Thank you for the meeting today and for your help. Please see the attached revised drawing showing the garden wall rebuilt some 500mm into the garden.

Further to this morning's meeting at Gladwyn, The Street, East Preston, I can confirm that I am satisfied with the proposed parking provision of 9 spaces as per revised plan provided by Mr Shaw on Friday (11th October).

From: Juan Baeza [REDACTED]
Sent: 10 October 2019 11:29
To: Nicola Fry
Cc: PETER SHAW
Subject: Gladwyn - East Preston

Project: Proposed new homes; Gladwyn, The Street, East Preston BN16 1HT			
Drawing: Block plan, bin store elevations			
For: Mrs. J. Simmonds & Mr. P. Beamish			
Drawn: PKS		Date: November 2018	
Scales: 1:50 1:200		No: 2386/01/03/C	
To scale when printed on A3

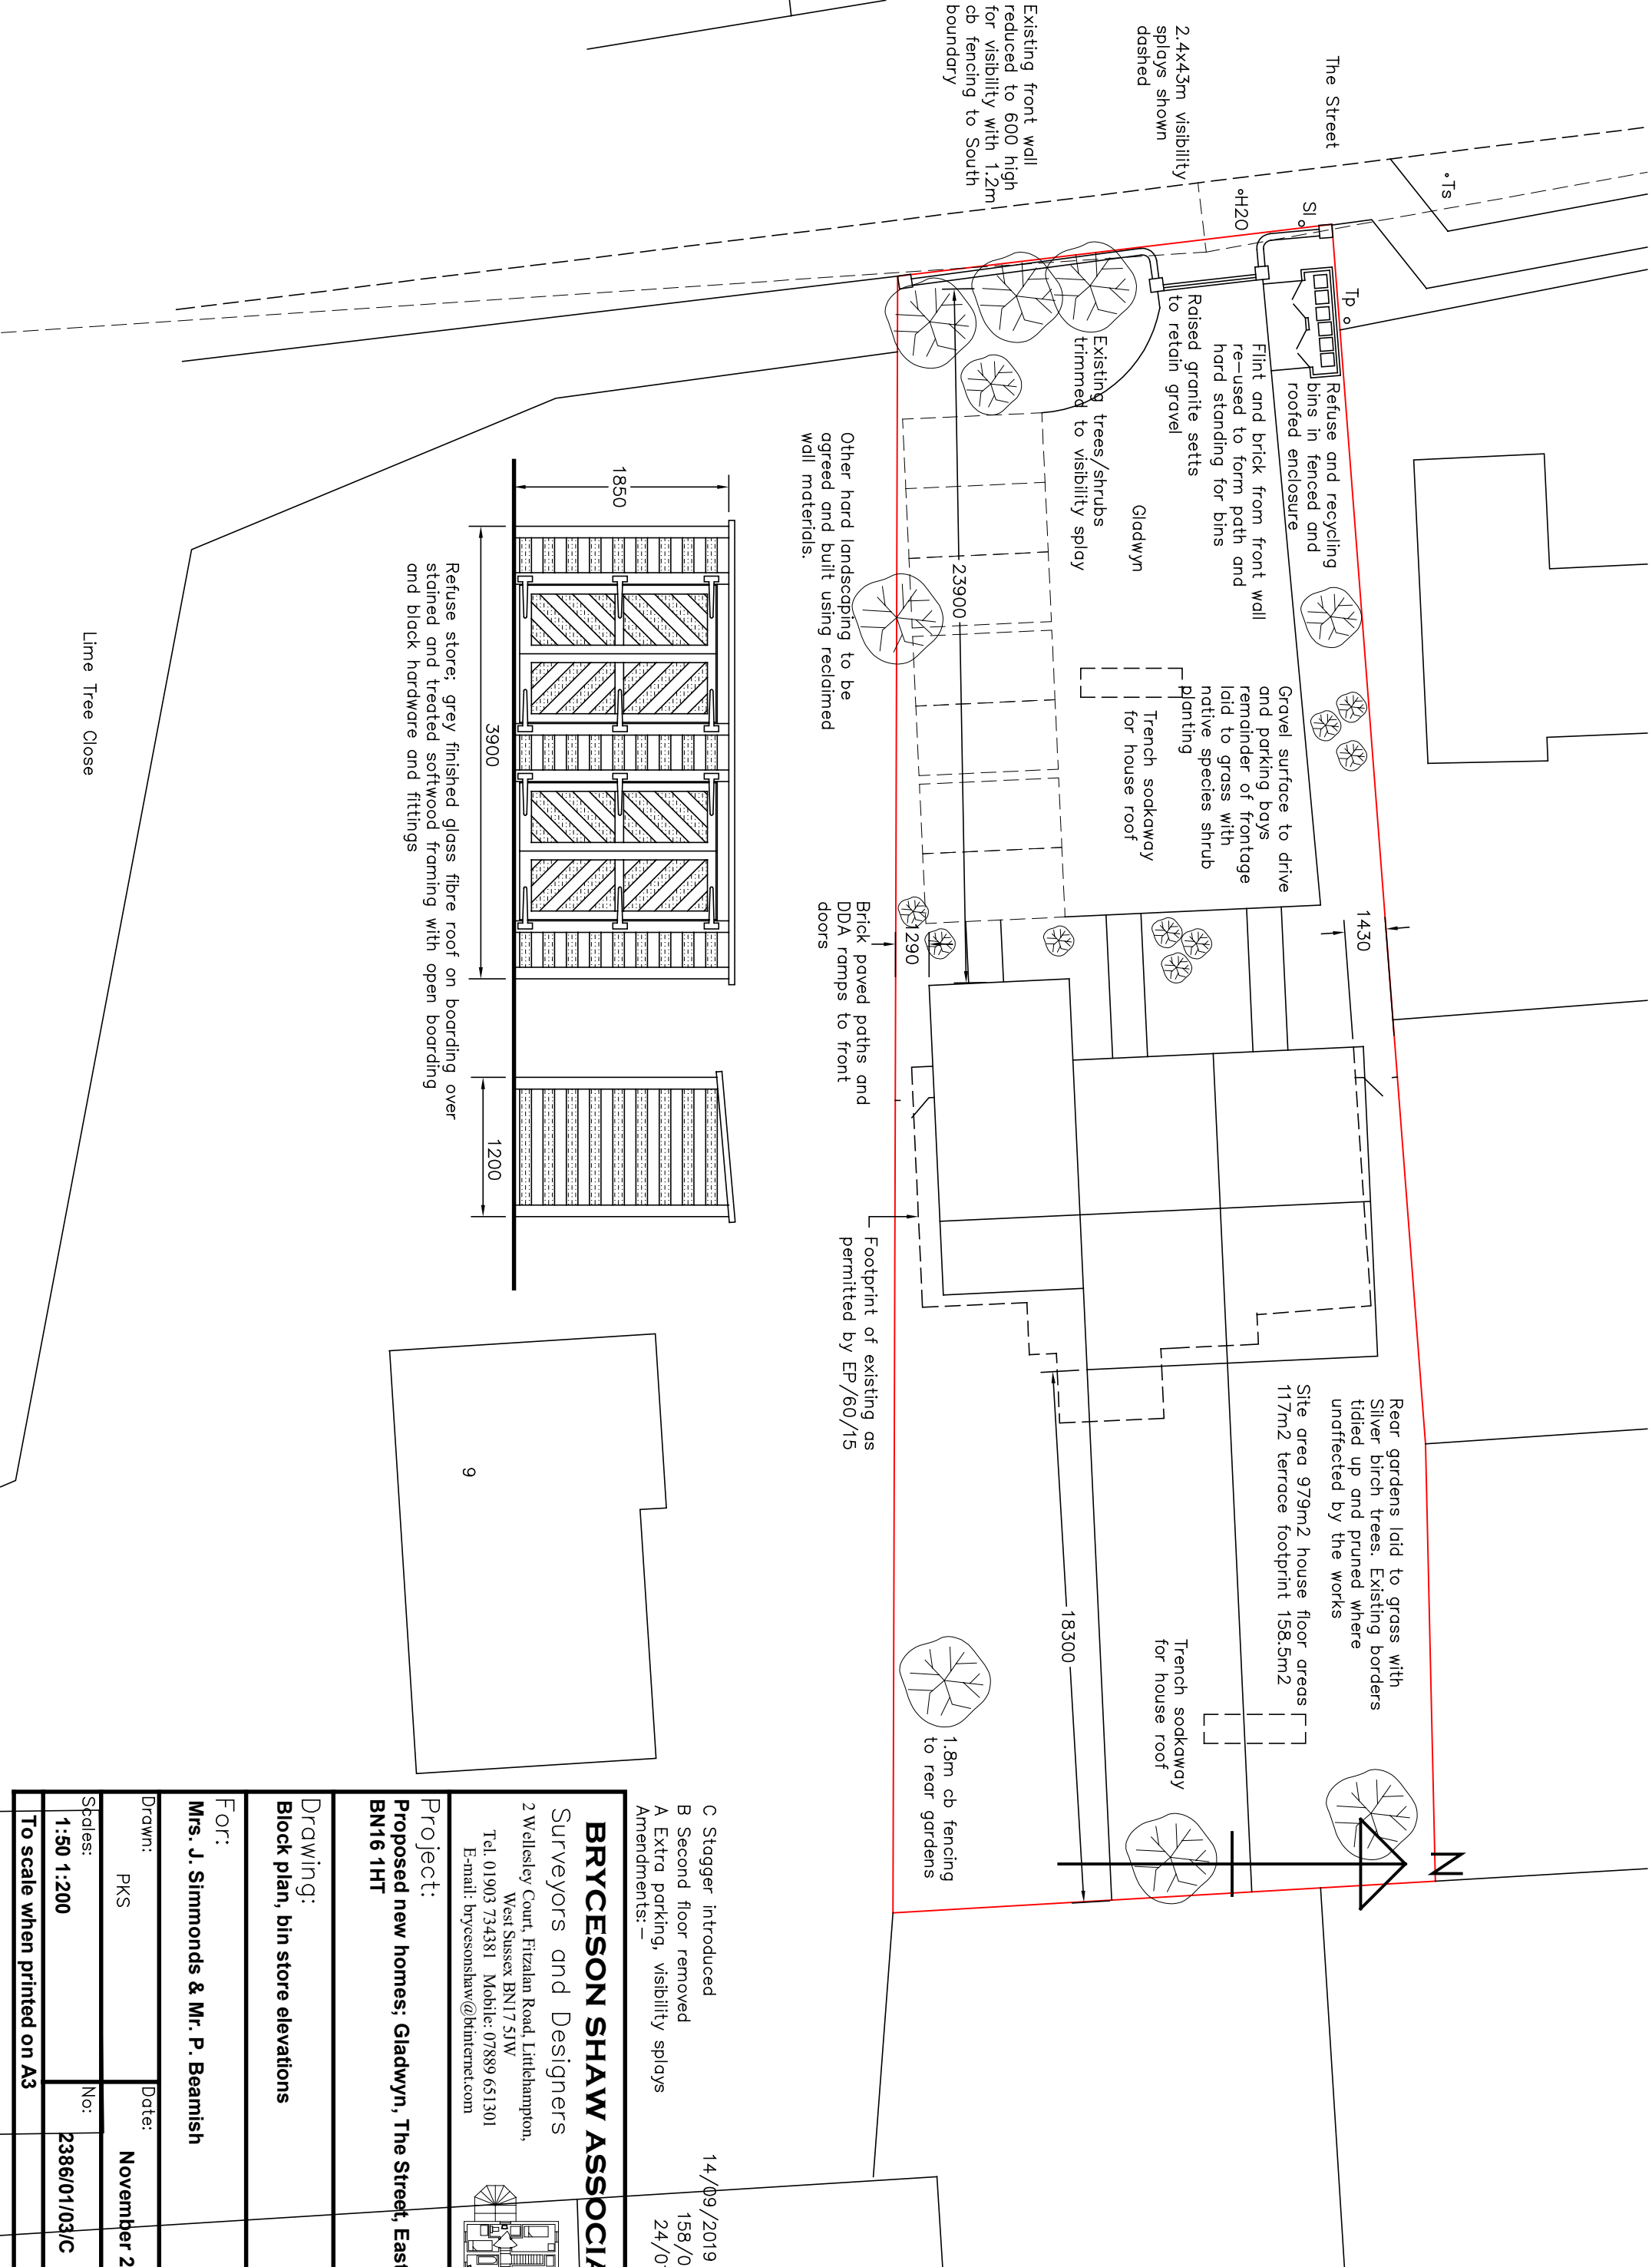
I would like to retain the Southern most brick pier as it defines the 2 boundaries of the plot and should not affect visibility. The final decision on this can be made once we start site clearance and can properly set things out.

With regards to the boundary wall, we measured visibility on site at a distance of 2.4m back from the carriageway edge. In the leading direction (to the north of the access) 43m visibility is achievable in accordance with Manual for Streets (MfS) standards, without any alterations to the existing wall required. In the trailing direction (to the south), visibility is obstructed by the wall and overgrown hedges.

The current height of the boundary wall is 1.2m. We discussed two options on site, firstly the reduction in height of the wall, and secondly relocating the wall within the site. In its current position, due to the proximity to the school, we would require the wall to be reduced in height to 600mm to allow visibility of small children. However, we did agree on site that a compromise could be reached and we would support the wall being reduced in height to 800mm. This option would still result in some loss of the wall. We then discussed the option of repositioning the wall to a set-back of 0.5m from its current position. It was agreed by all that this would be the favoured option as it is anticipated to provide a full unobstructed visibility splay of 43m to the south and would not result in any loss of the flint wall.

Subject to a revised plan confirming that a 0.5m set-back would provide the required 43m splay to the south, I would not consider that this proposal would have an unacceptable impact on highway safety or result in 'severe' cumulative impacts on the operation of the highway network, therefore is not contrary to the National Planning Policy Framework (paragraph 109), and that there are no transport grounds to resist the proposal.
